Land Adjacent to No 70 Violet Avenue
Uxbridge
UB8 3PT

Planning Application
Design & Access Statement

16/03/2018

Proposed First Floor Plan: Flat 02 - 70sqm

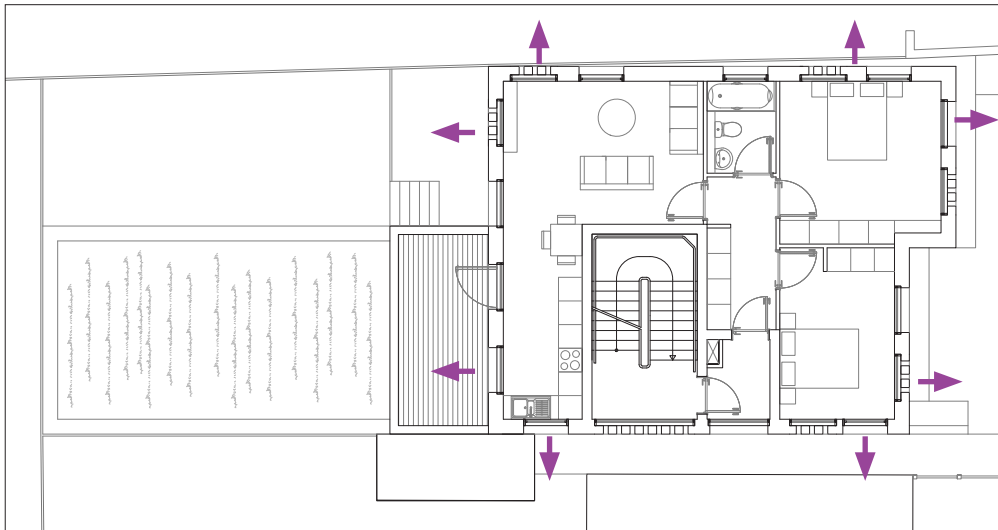
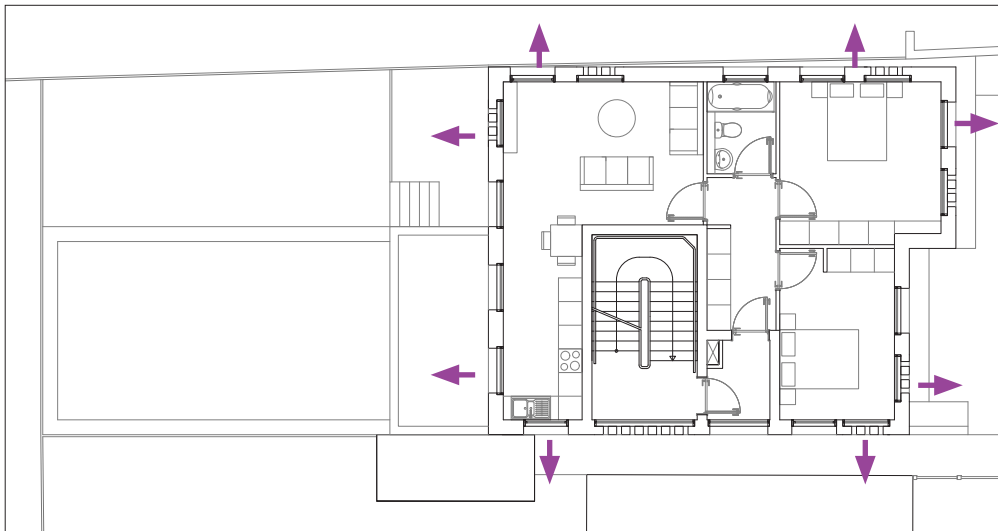
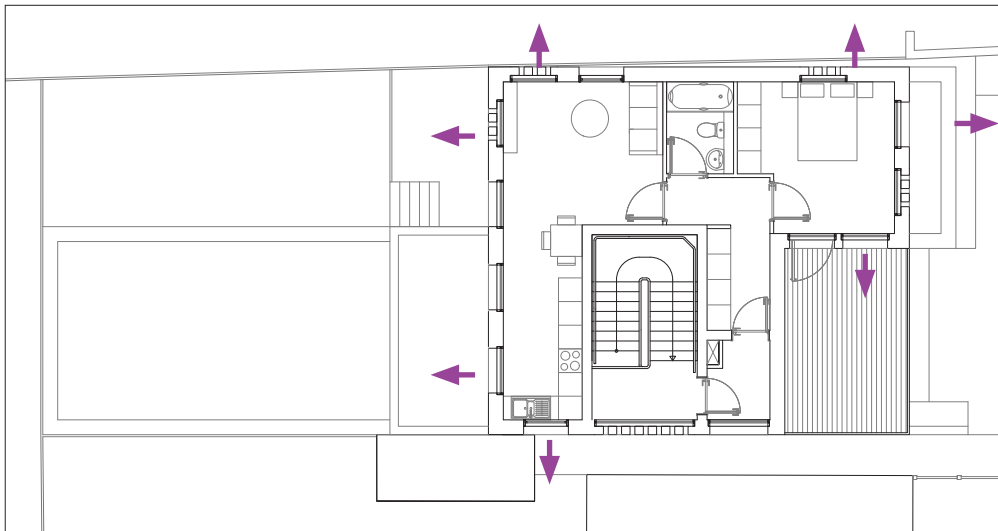
COMMENT: Area of 2 bed flats is 1sqm below LP standards
RESPONSE: These flats are now 70sqm; in line with LP standards.
